Ref: FP/48/12/ 39, Davenport Road, Felpham, Bognor Regis.

From: Katherine Rawlins
Sent: 21 June 2012 11:52
To: [REDACTED]
Subject: 39 Davenport Road, Felpham
Dear Mr Martin,

From: Katherine Rawlins
Sent: 17 July 2012 11:33
To: [REDACTED]
Subject: 39 Davenport Road, Felpham

NEW SOUTH ELEVATION

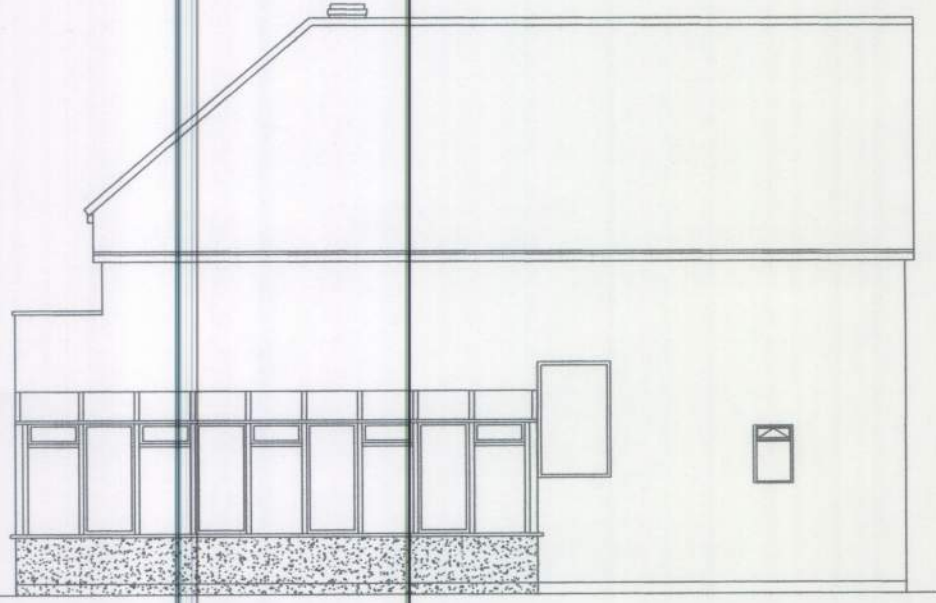
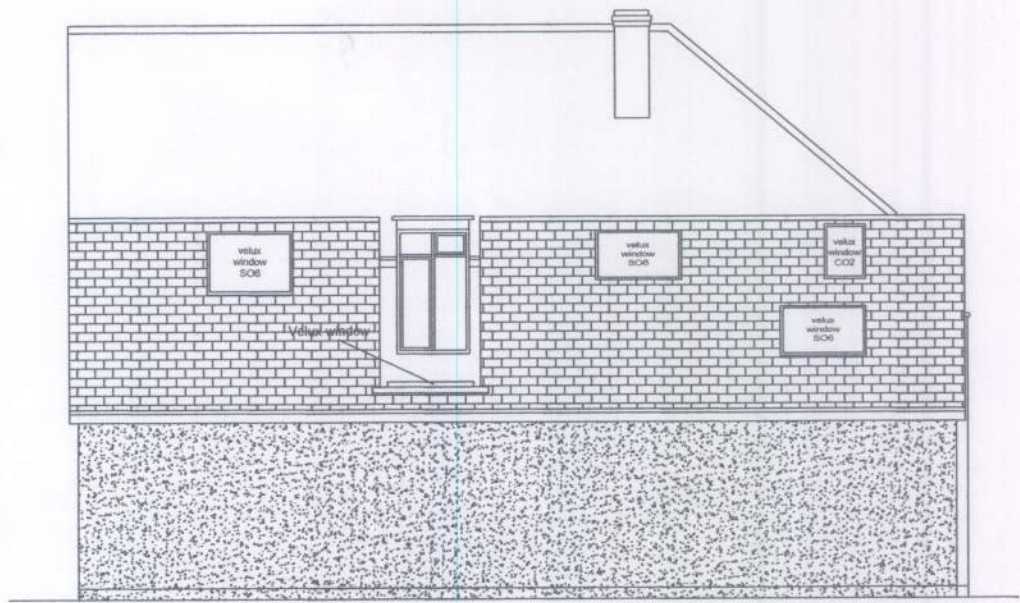
My only other outstanding query relates to the height of the extension in relation to the eaves/side facing window. The ridgeline still appears to be above eaves height when viewed from the side, yet from the front elevation, it appears to be in line with the eaves?

Set back of 150mm from the side boundary adjoining no. 37 and retention of existing fence;
Set back of 1100mm to be in line with the front elevation of the dwelling;
Proposed extension in line with existing eaves height.

SITE PLAN

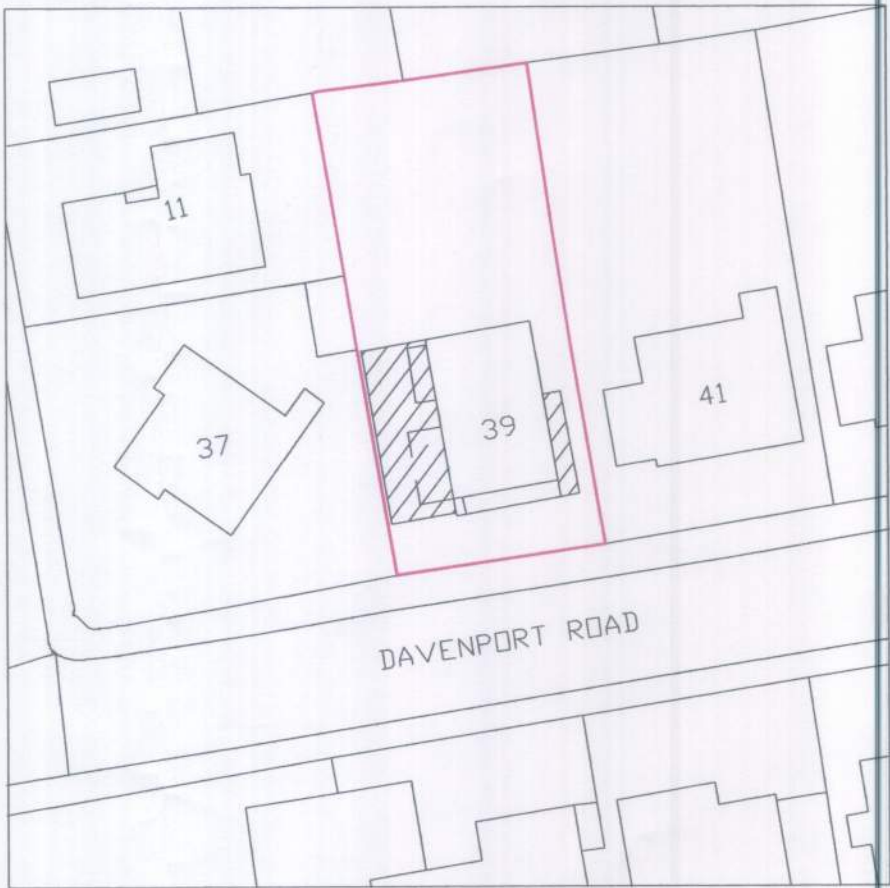
The set back from the front elevation of the dwelling needs to be shown on the proposed site plan, as this still shows a projection up to the front balcony.
